RECOMMENDATIONS FOR
RENOVATION OF EXISTING
STRUCTURE AT 51 WATERVILLE,
PORTLAND, ME.

Albert Putnam PE
Project: BIRCHOT / PARKER
Date: 5.11.12
Sheet 1 / 4

SE. ELEV. NEW ADDITION  
1/4" = 1'-0"  
02.23.2012

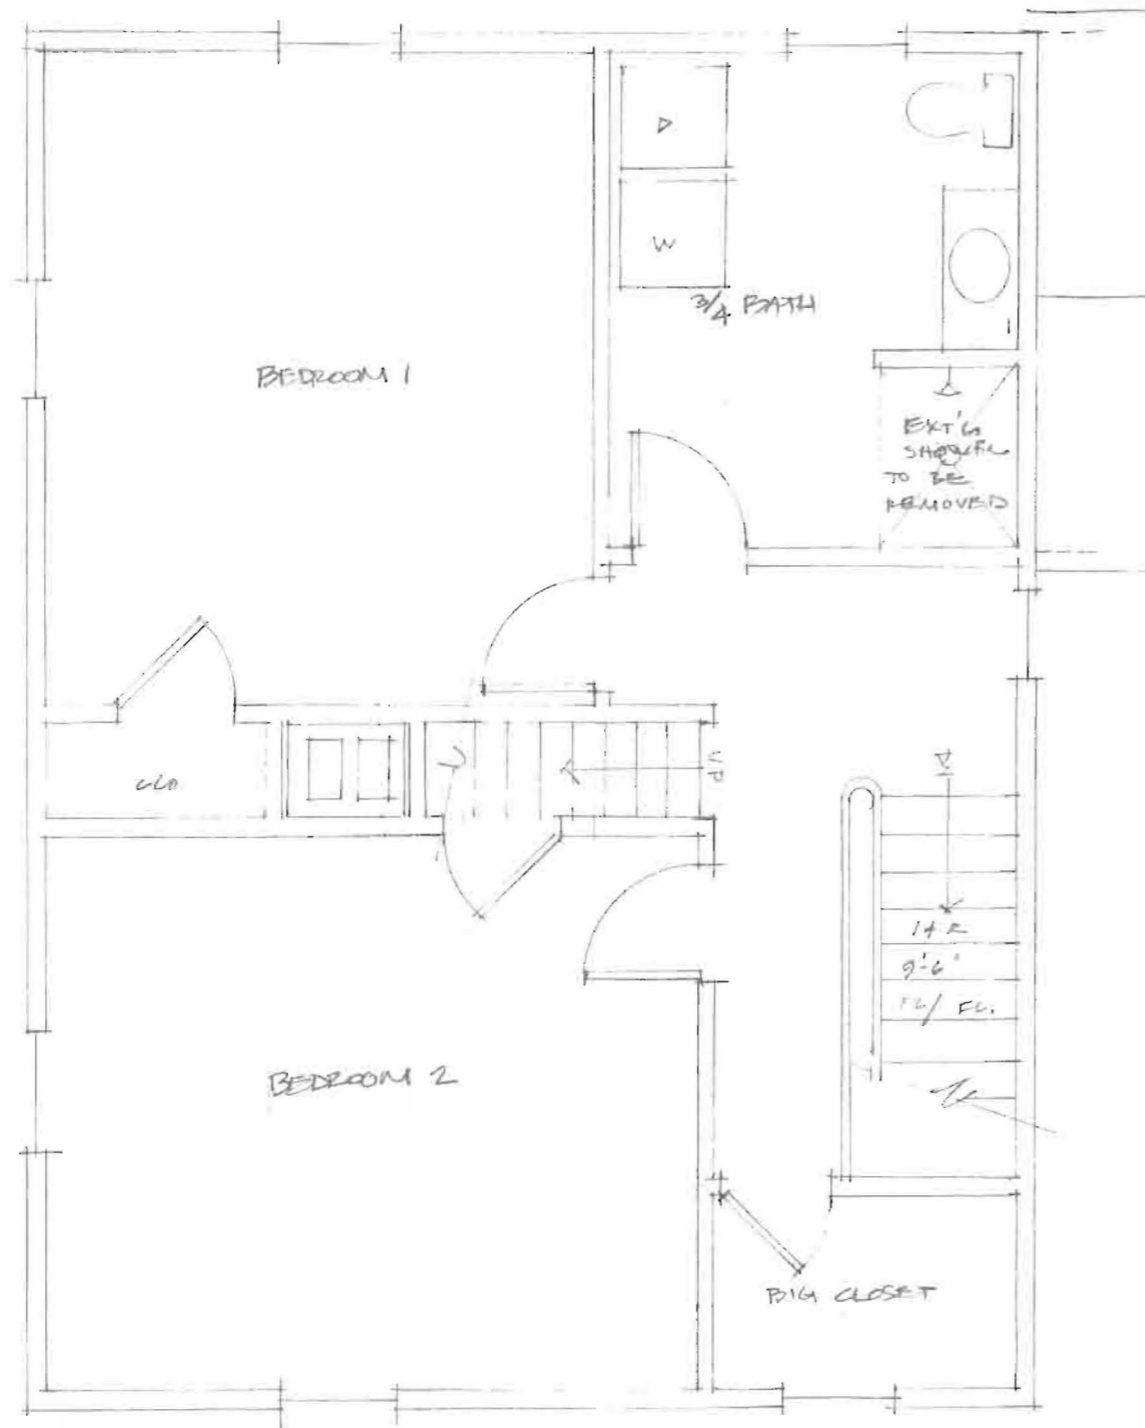
2-PT 6x6 POST IN BEAM
ON 10'x30'x30" FTR
WITH 4 #4 EX UNITS
AT BOTTOM w/ 3" COVER

3-12x9 LVL @ FIRST FLOOR
BELOW DAMAGED TIMBER

3-12x9 LVL @ SECOND FLOOR

FIRST FLOOR PLANKING
SHRUB EXIST JOISTS
WITH 2x8 IF
SHIPPING IS REMOVED.

3<sup>RD</sup> FL STAIR/BATH/LAUNDRY 2<sup>ND</sup> FLOOR PLAN - 1/4" = 1'-0" 02.23.2012

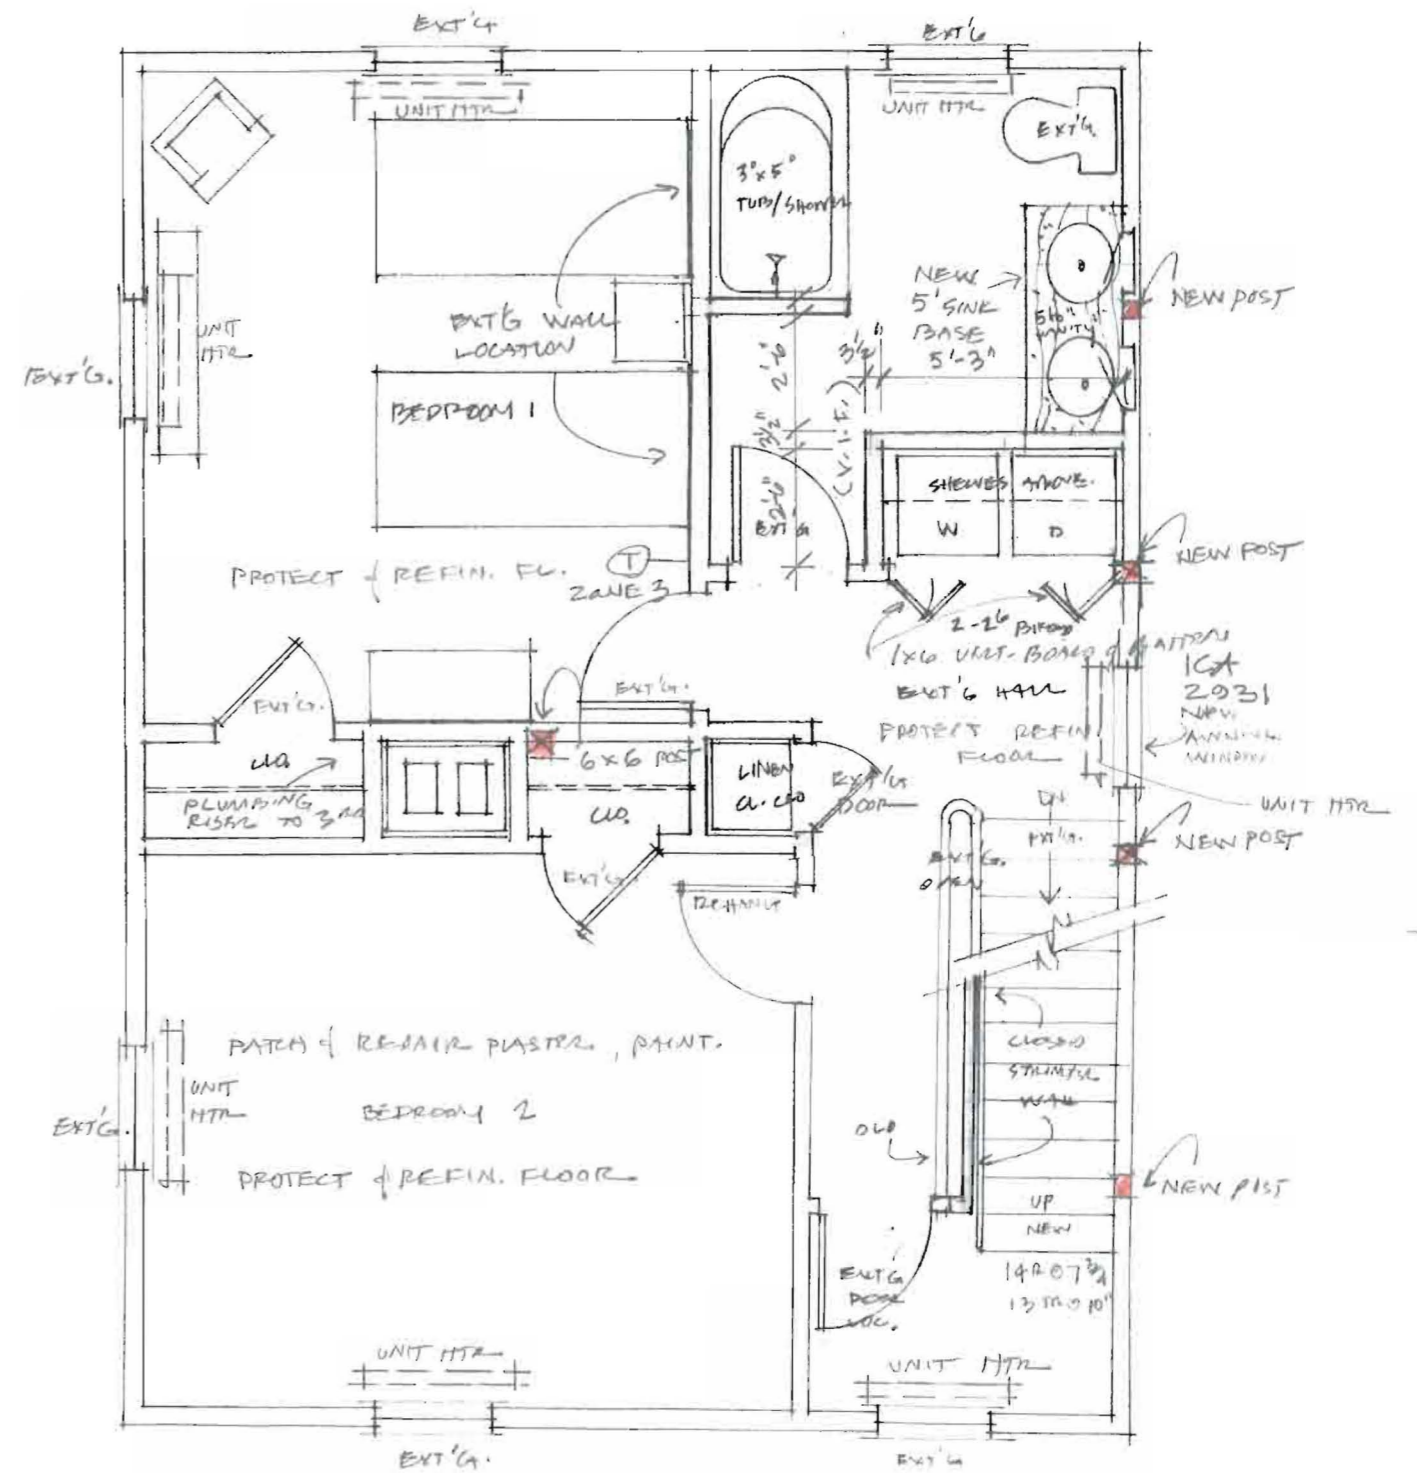
SIGNIFICANT ADDITIONAL DEAD LOAD
ON EXIST. JOISTS, RECOMMEND SISTERING
2x6 JOIST FULL LENGTH TO EXISTING TO
HELP STIFFEN FLOOR IN ADVANCE OF TILE & SHOWER.

INSTALL 2x2x4 WALLS (TIP)
INSTALL 2x4 JACK SCRAPES
ON 2x8 HEADERS BETWEEN
POSTS TO CARRY EXIST. LOAD

3RD FLOOR MASTER SUITE, NEW DORMER, NEW STAIRS 1/4" = 1'-0" 02.23.2012

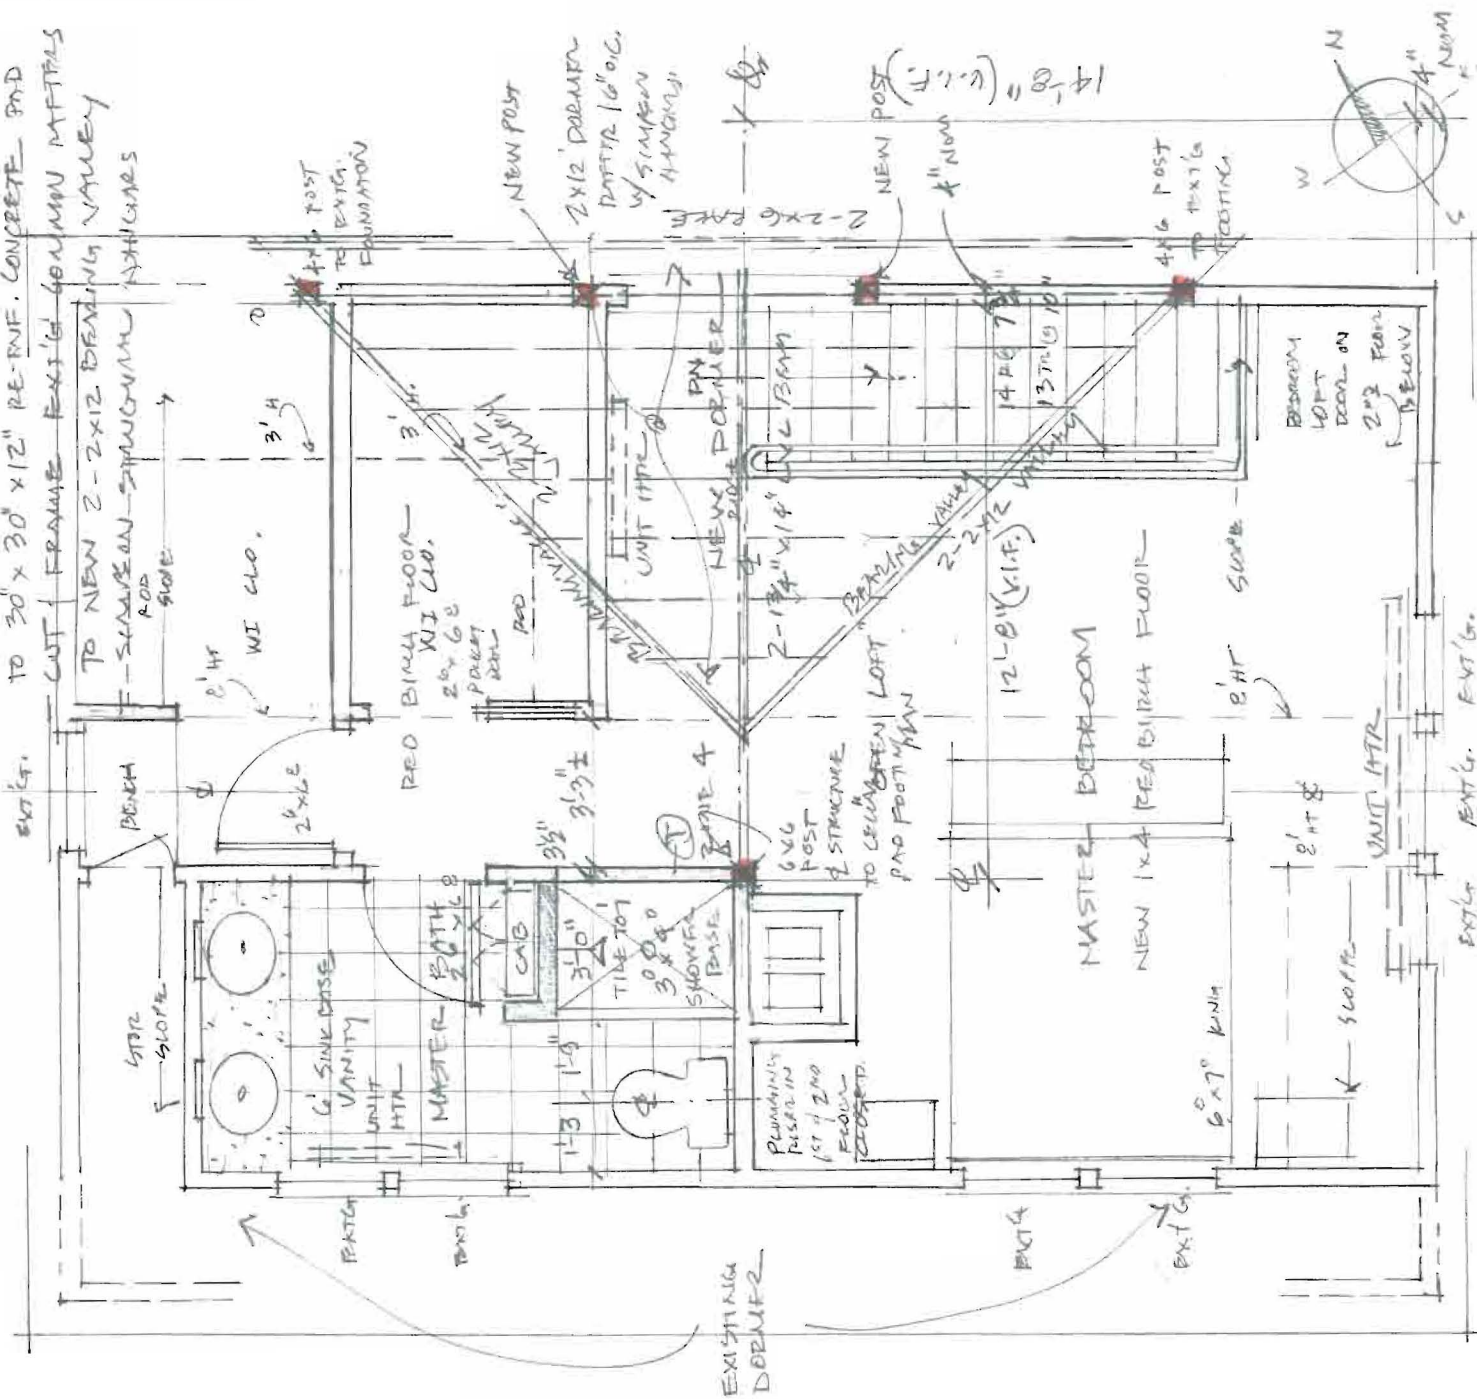
REMOVE EXT'G DN CEILING & INSULATION
INSTALL NEW DORMER LVL BRAM
NEW 6x6 POST IN INTERIOR PARTITION
TO 30"x30"x12" RE-TRF. CONCRETE PAD
CUT FRAME EXT'G COLUMN AFFERS
TO NEW 2-2x12 BRAMING VALLEY

(2) - 5/8" ϕ BOLTS THROUGH
VALLEY / RIDGE / VALLEY

SIMPSON
H2.5 CLIP AT
6x7 KNUIT ALL
RAFTERS

SISTER RAFTERS
WITH MIN 2x8
OR PER APTS
(TIP)
